Application Reference: EN010056

Our Reference: DIO 17608

The East Anglia Three Offshore Wind Farm Order 2017 (as amended) Application for a Non-material Change 2020
Infrastructure Planning (Changes to, and Revocation of, Development Consent Orders) Regulations 2011 (as amended) (2011 Regulations) (Application)

Doc Reference	2.11
APFP Regulation	5(2)(o)
Date	October 2015
Author	East Anglia THREE Limited
Revision History	A

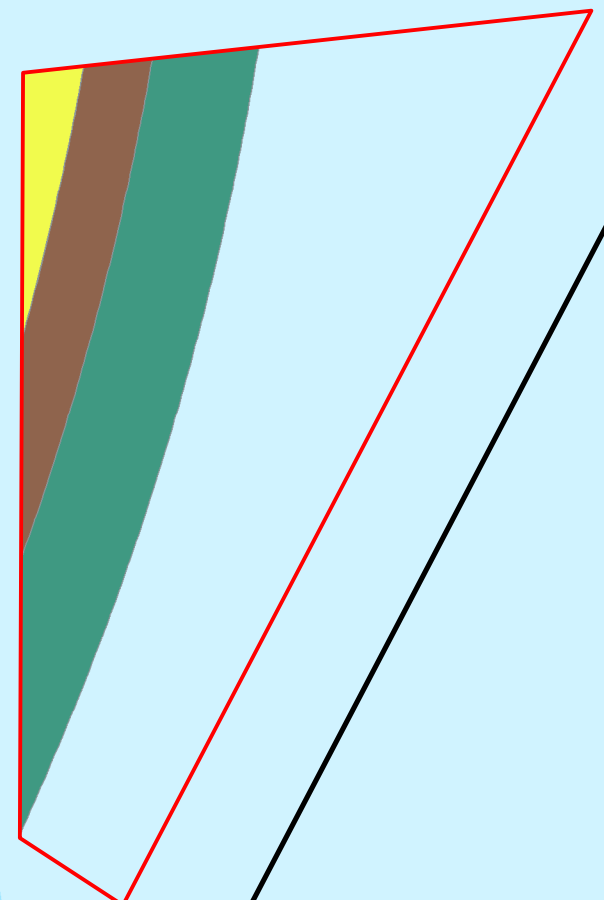
This issue has been recognised by the applicant, who has correctly determined that the development will have major and significant impacts upon the air defence radar if not mitigated. The applicant has undertaken to assess the impacts that the wind farm will have upon the air defence radar to define siting and design parameters of turbines to address this impact. However, the full performance attributes of this radar type are not available in the public domain. Therefore, whilst the radar modelling undertaken on behalf of the applicant serves to provide an approximate indication of the impacts the wind farm is likely to have, it is not able to accurately account for the full extent to which the air defence radar will be able to detect the wind turbines. The applicant has sought to make amendments to sub-paragraph (2) (d) of Requirement 33 of the 2017 DCO relating to MOD surveillance operations.

The proposed amendments would serve to redefine the maximum heights that wind turbines deployed in specific areas of the offshore development envelope (defined in a plan appended to the 2017 DCO) could be built up to without requiring a technical mitigation. As identified above, the applicant's modelling of the radar detectability of turbines that may feature in this scheme is not suitable for precisely defining the maximum heights turbines could be built up to within specific areas of the development envelope without causing unacceptable and unmanageable interference to the air defence radar. The MOD does not consider that such precise development limitations can be prescribed in this way whilst ensuring the effective operation of the air defence radar. Since the height parameters defined in the 2017 DCO were agreed, the MOD has completed radar trials and gained a greater understanding of the regular performance attributes of the type of air defence radar system in use at RRH Trimingham. As such, this use of siting and design parameters to address air defence radar safeguarding requirements is no longer suitable.

Therefore, in my letter of the 30th September 2020, it was identified that the MOD cannot accept the amendment of Requirement 33 as was proposed. Instead, the MOD put forward an alternative version of this Requirement using wording that the MOD considered suitable for the purpose of addressing air defence safeguarding requirements based on current information and understanding, by identifying a need for the provision of a technical mitigation.

(1) No wind turbine generator forming part of the authorised development is permitted to rotate its rotor blades on its horizontal axis until the Secretary of State having consulted with the Ministry of Defence confirms satisfaction in writing that appropriate mitigation will be implemented and maintained for the life of the authorised development and that arrangements have been put in place with the Ministry of Defence to ensure that the approved mitigation is implemented.

(a) “appropriate mitigation” means measures to prevent or remove any adverse effects which the authorised development will have on the air defence radar at Remote Radar Head (RRH) Trimingham and the Ministry of Defence’s air surveillance and control operations;

(b) “approved mitigation” means the detailed Radar Mitigation Scheme (RMS) that will set out the appropriate measures and timescales for implementation as agreed with the Ministry of Defence at the time the Secretary of State confirms satisfaction in writing in accordance with paragraph (1);
